To speed up the discussion process and to avoid any confusion can you submit first and second floor layout plans with the extent and height of balcony screening to the east and west elevations clearly marked.

Thank you for the Decision Notice for K/2/20/DOC, which confirms acceptance of Condition 7 [materials and finishes]. The Condition submission also covered Condition 4 [balcony glazing details]. Can you confirm that this is also covered by the Decision Notice?

PROPOSED EAST ELEVATION

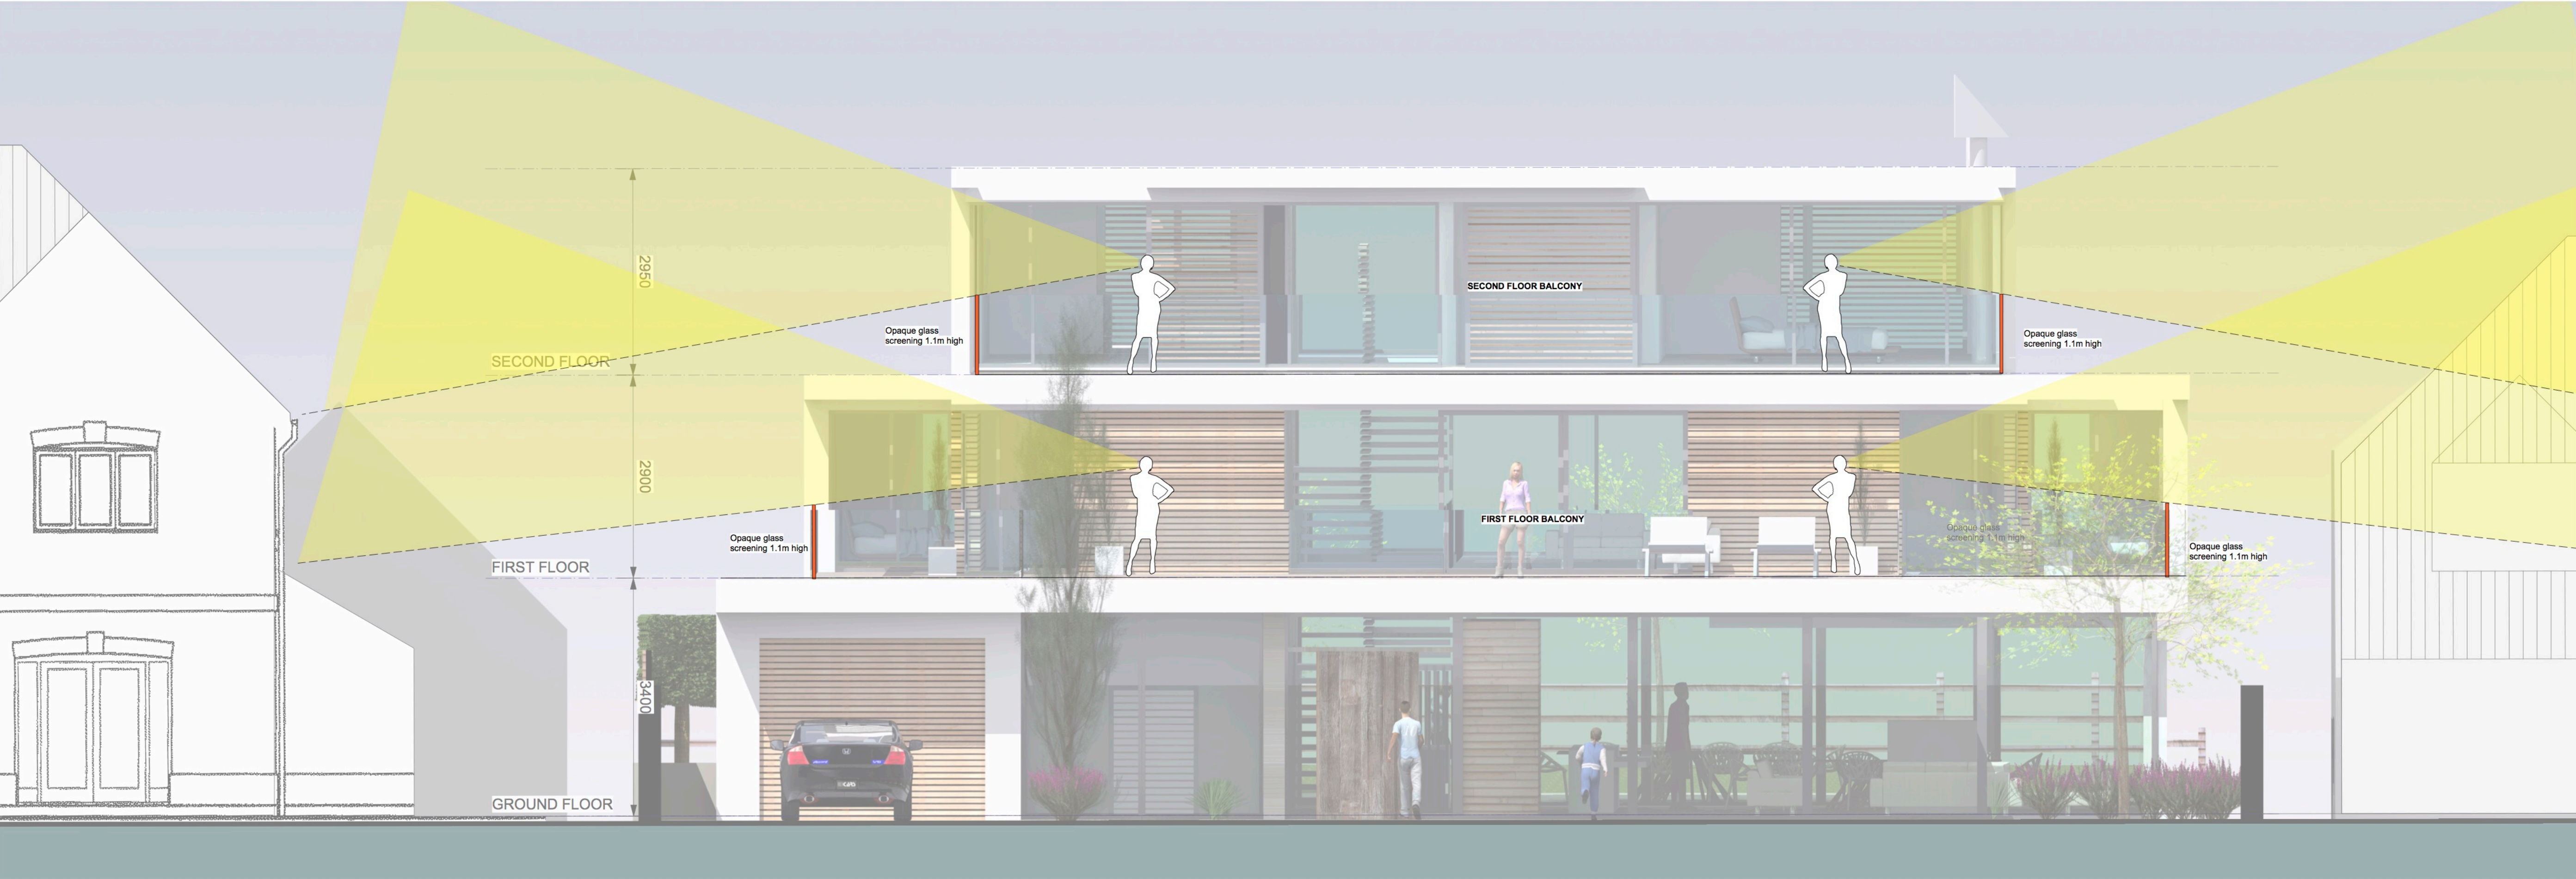
The other condition is not covered by the decision notice a separate letter will be issued shortly, but I need to discuss the submitted information with my Team Leader first. I am not sure that the sides are sufficiently high.
